January 6, 2020

RE: **Lot 4 Block 5, S.A.D. 227**  
**Unser Cliffs Subdivision**  
**6512 Onyx Ct. NW**  
**Grading and Drainage Plan**  
**Engineers Stamp Date 1-3-20 (E10D071)**

RE: **Lot 4 Block 5, S.A.D. 227**  
**Unser Cliffs Subdivision**  
**6512 Onyx Ct. NW**  
**Grading and Drainage Plan**  
**Engineers Stamp Date 12-23-19 (E10D071)**

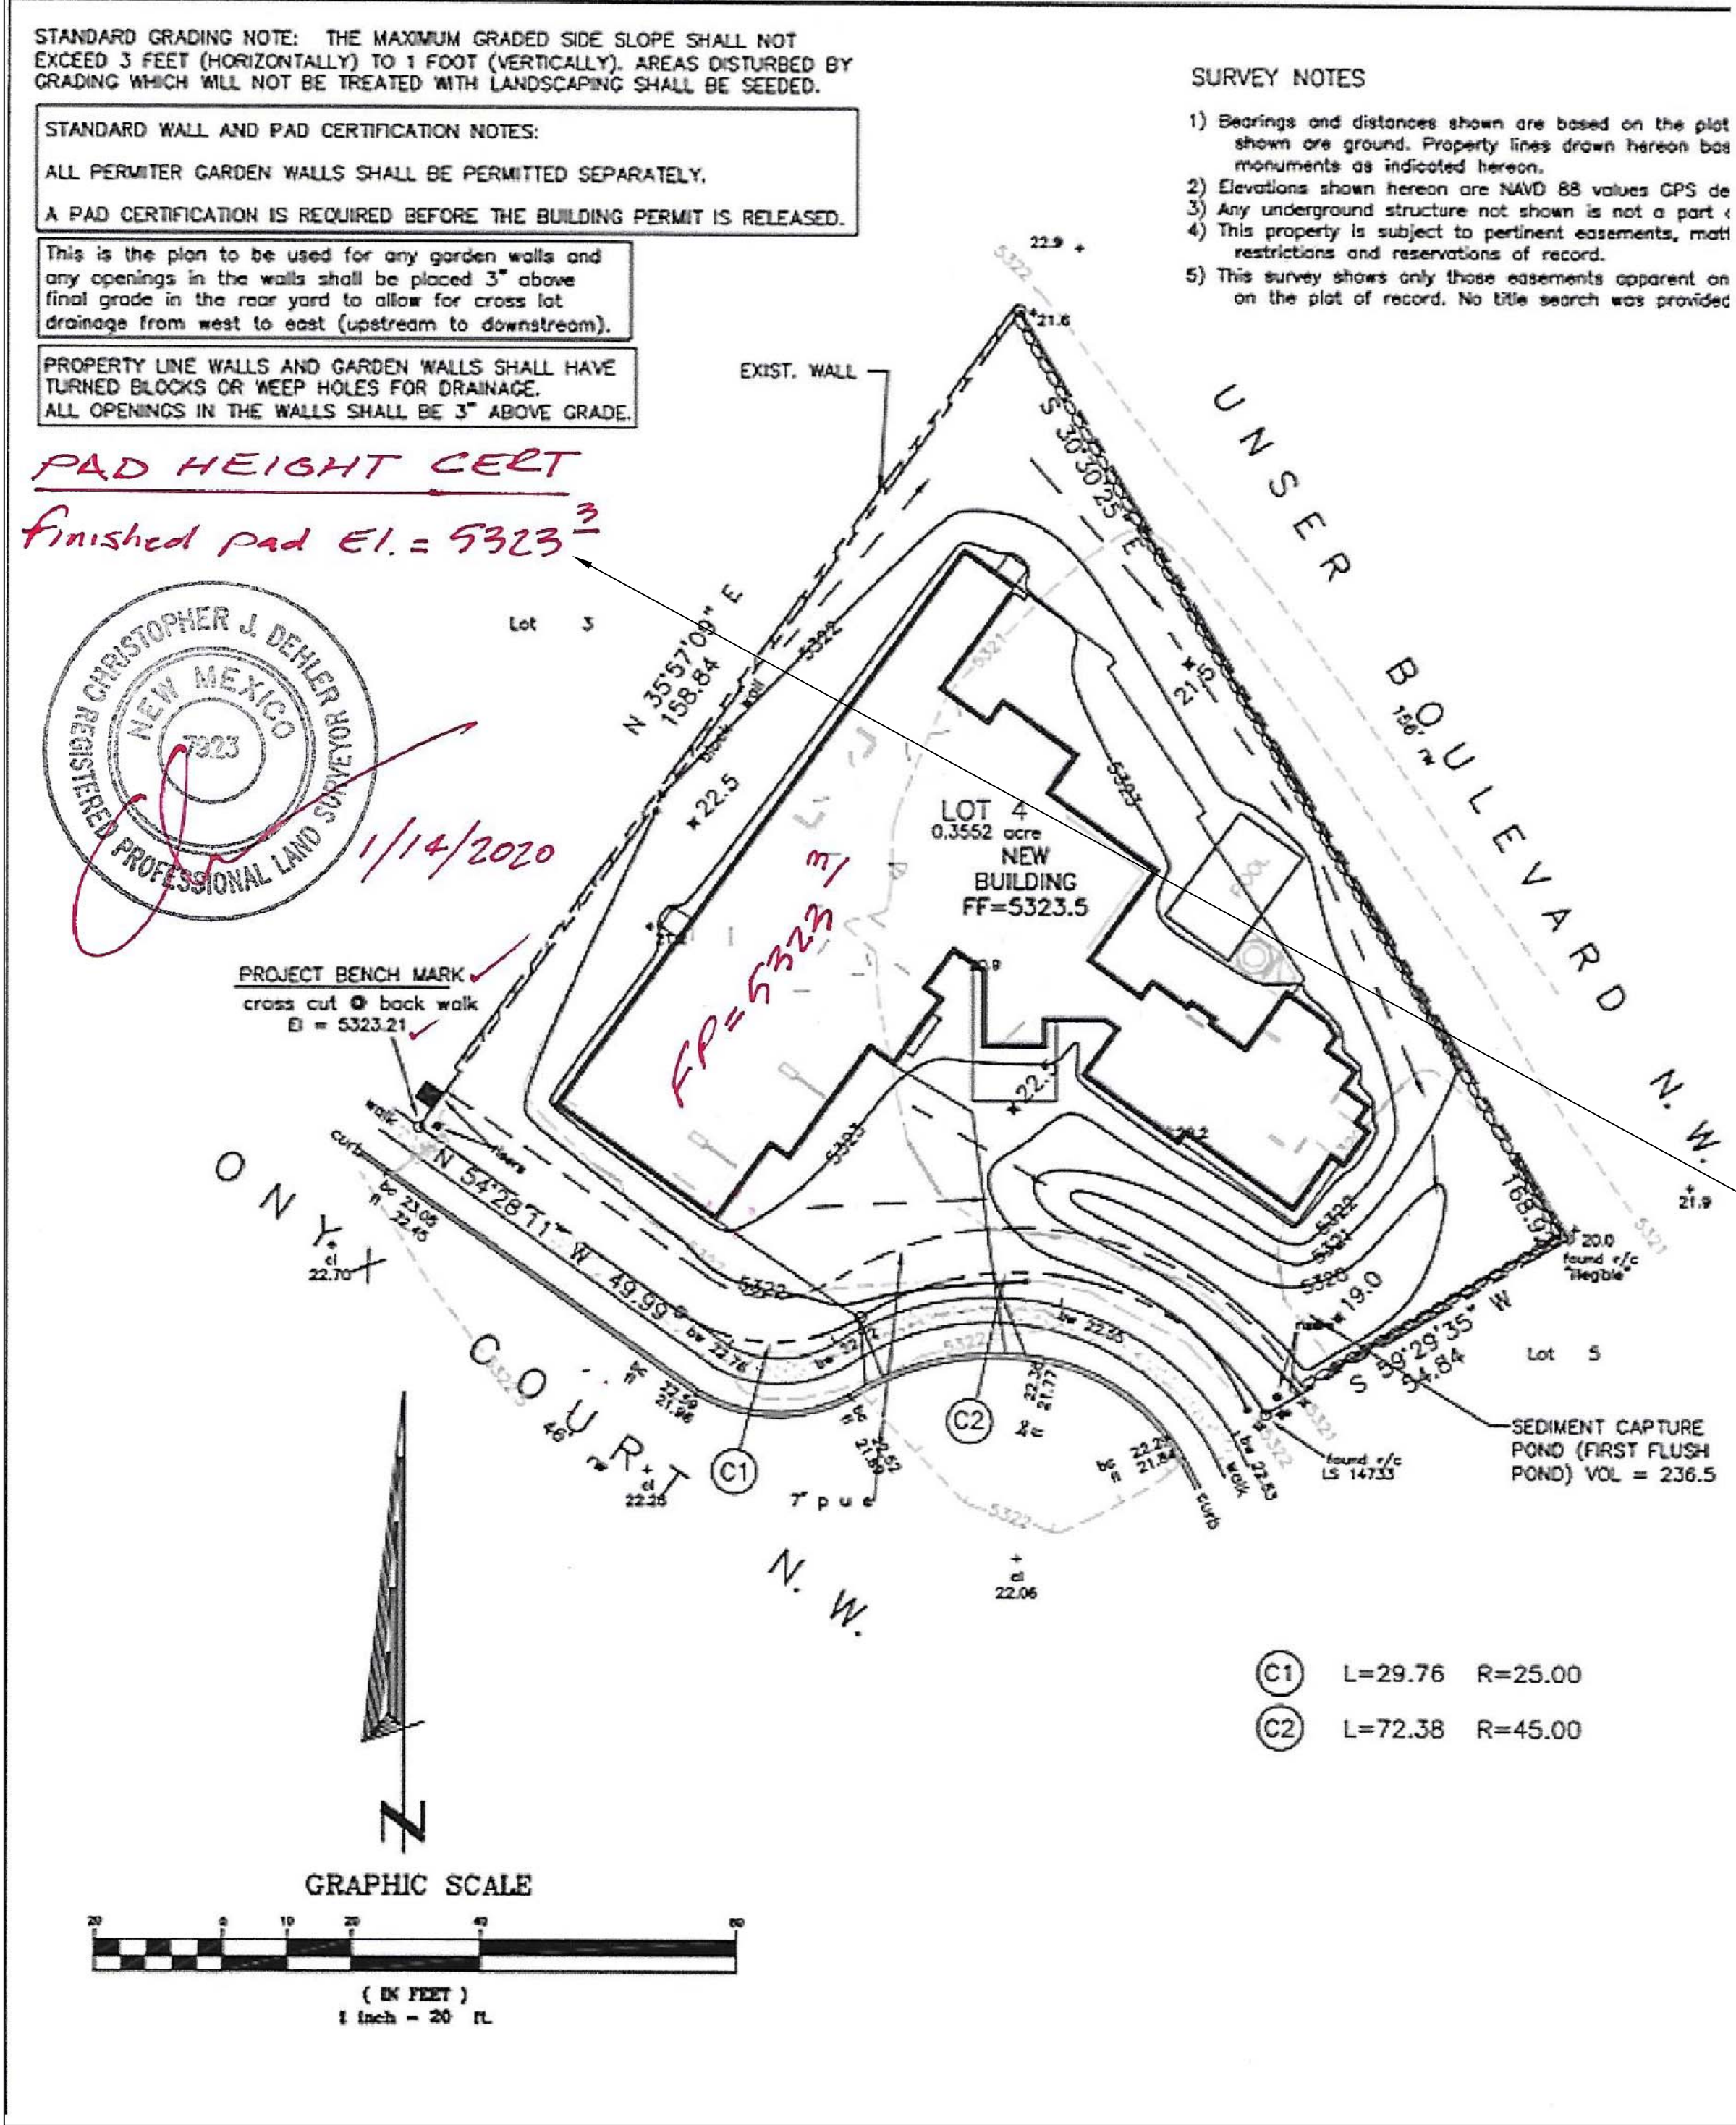
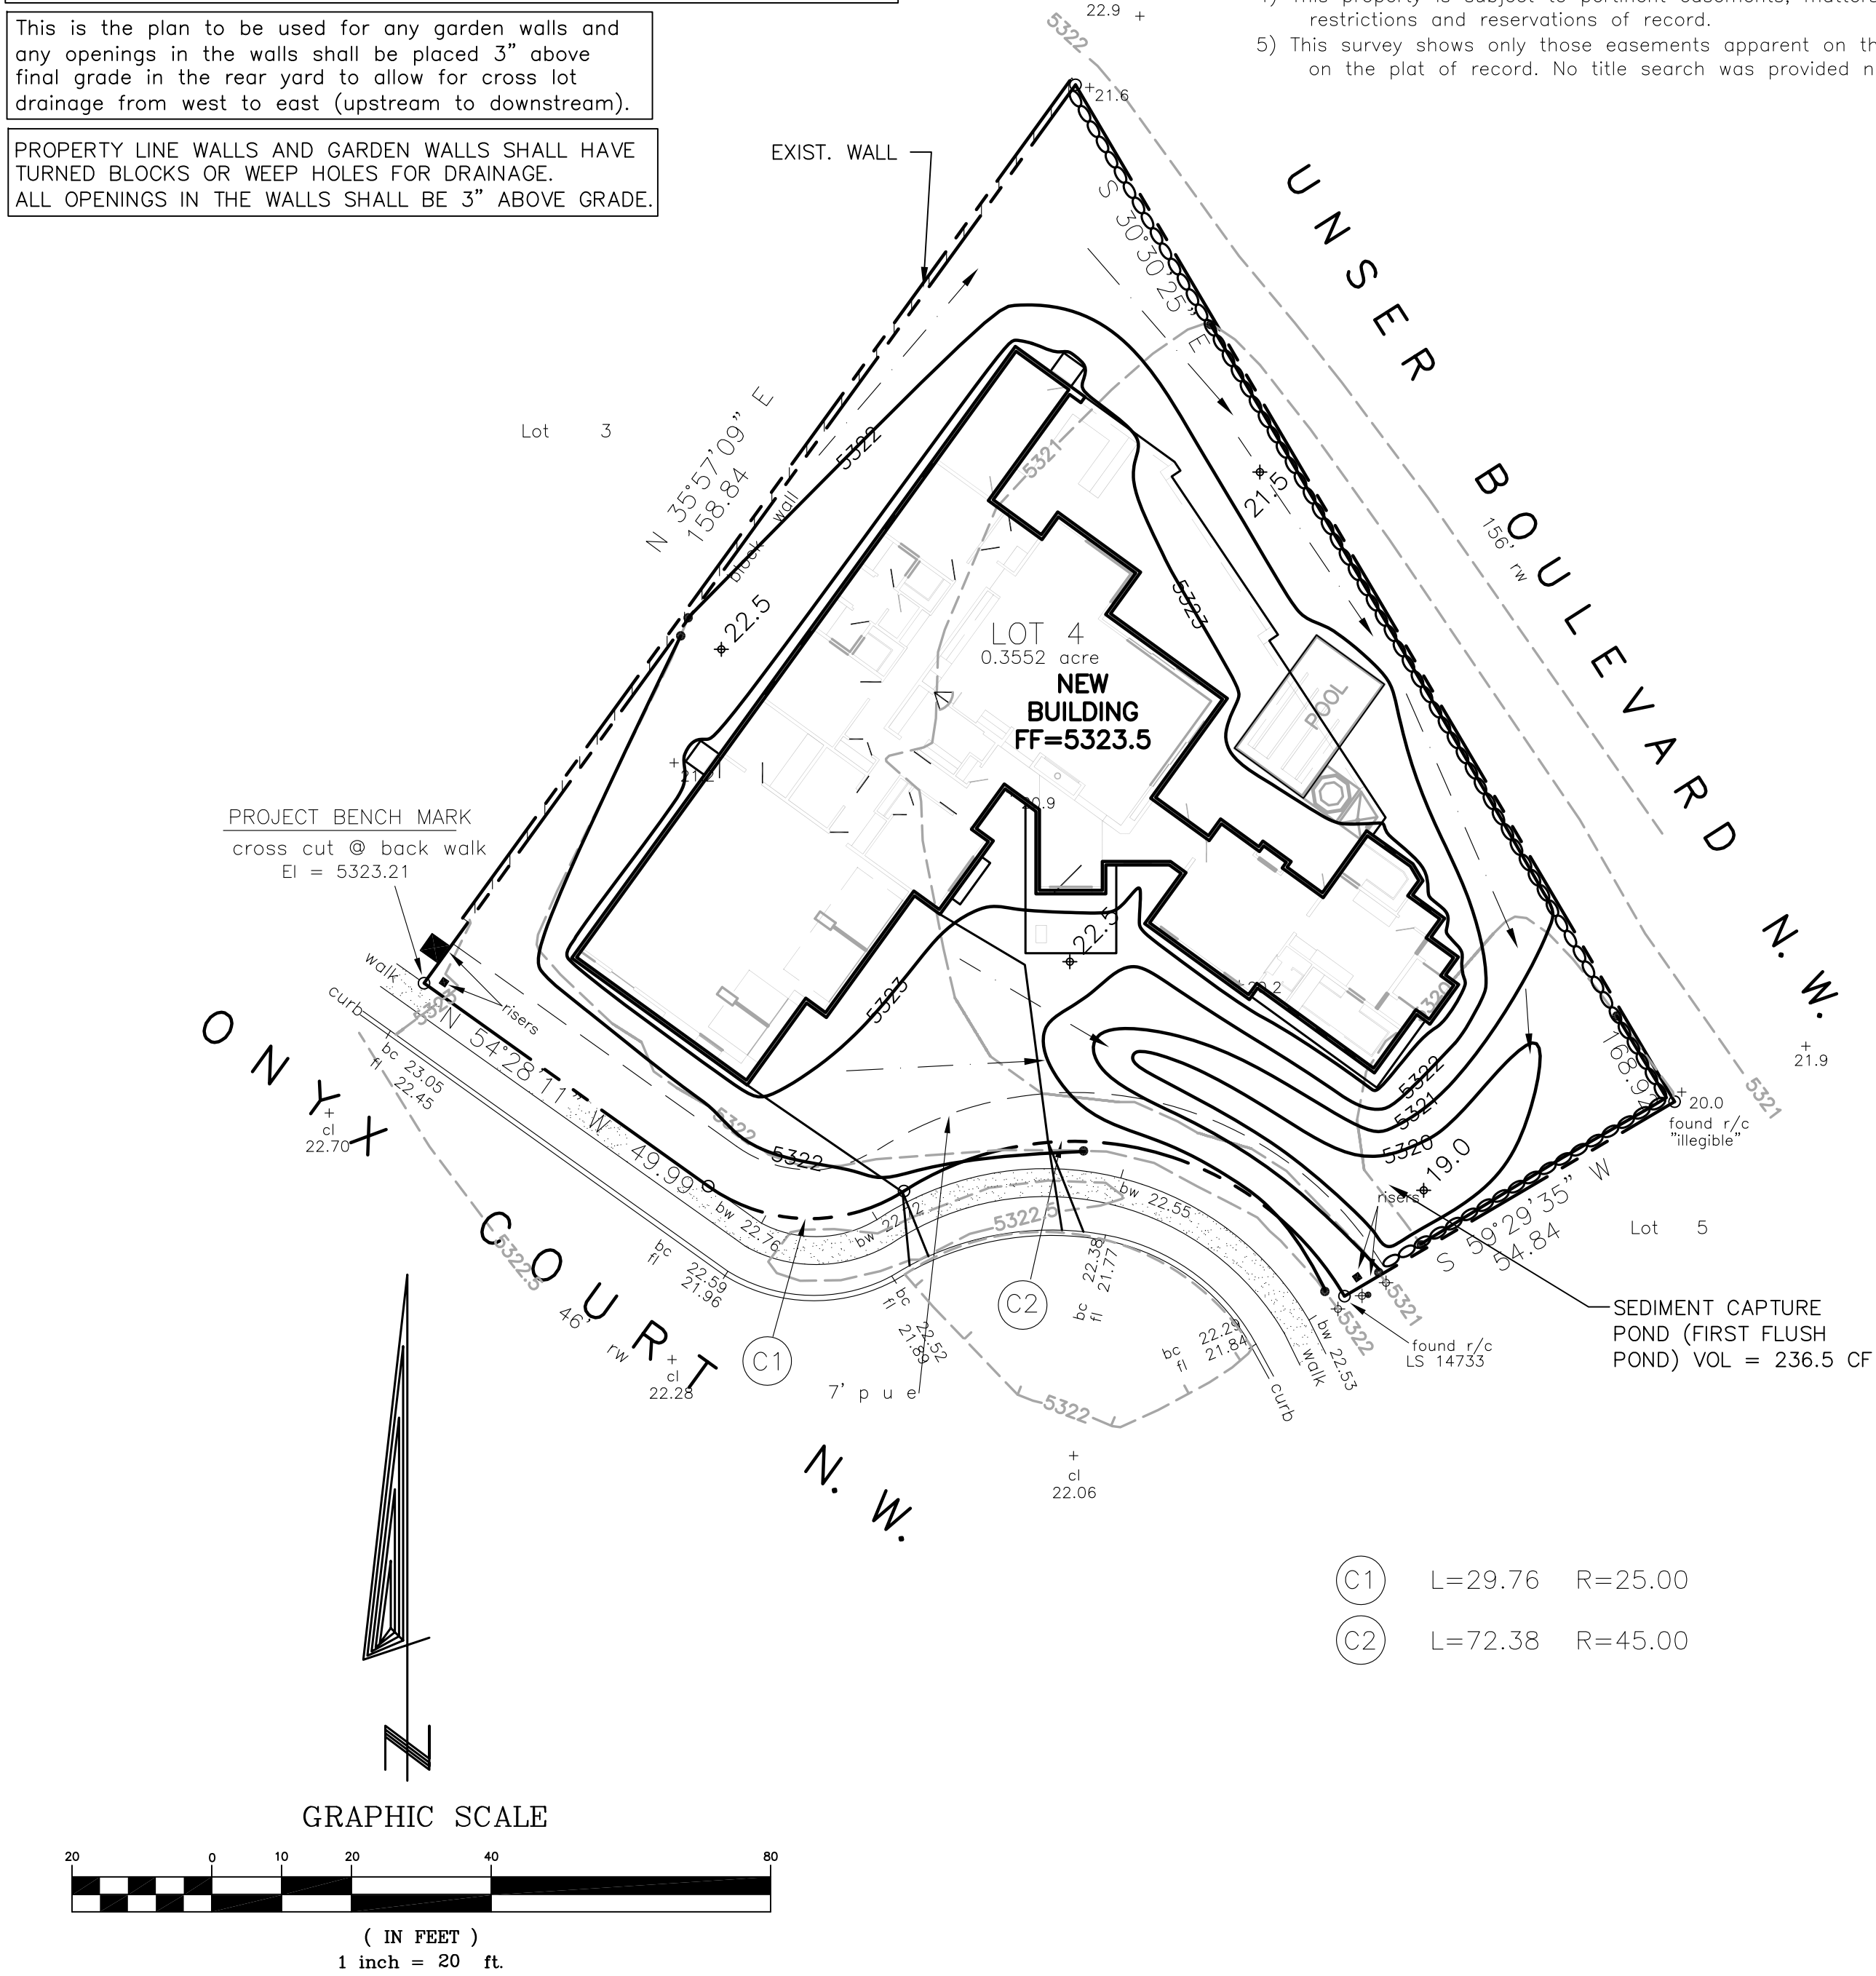
- Direct all flows to exit onto Onyx Ct. through a sediment capture pond. **OK- revised**
- Cross lot drainage is not required; remove the turn blocks on the eastern garden wall. **OK- revised**
- Provide a percentage for land treatment C. **OK - revised**
- Notify the owner/contractor not to use dirt as a ramp to climb the curbing, may use lumber or crusher fines for this function. **The owner is copied with this response.**
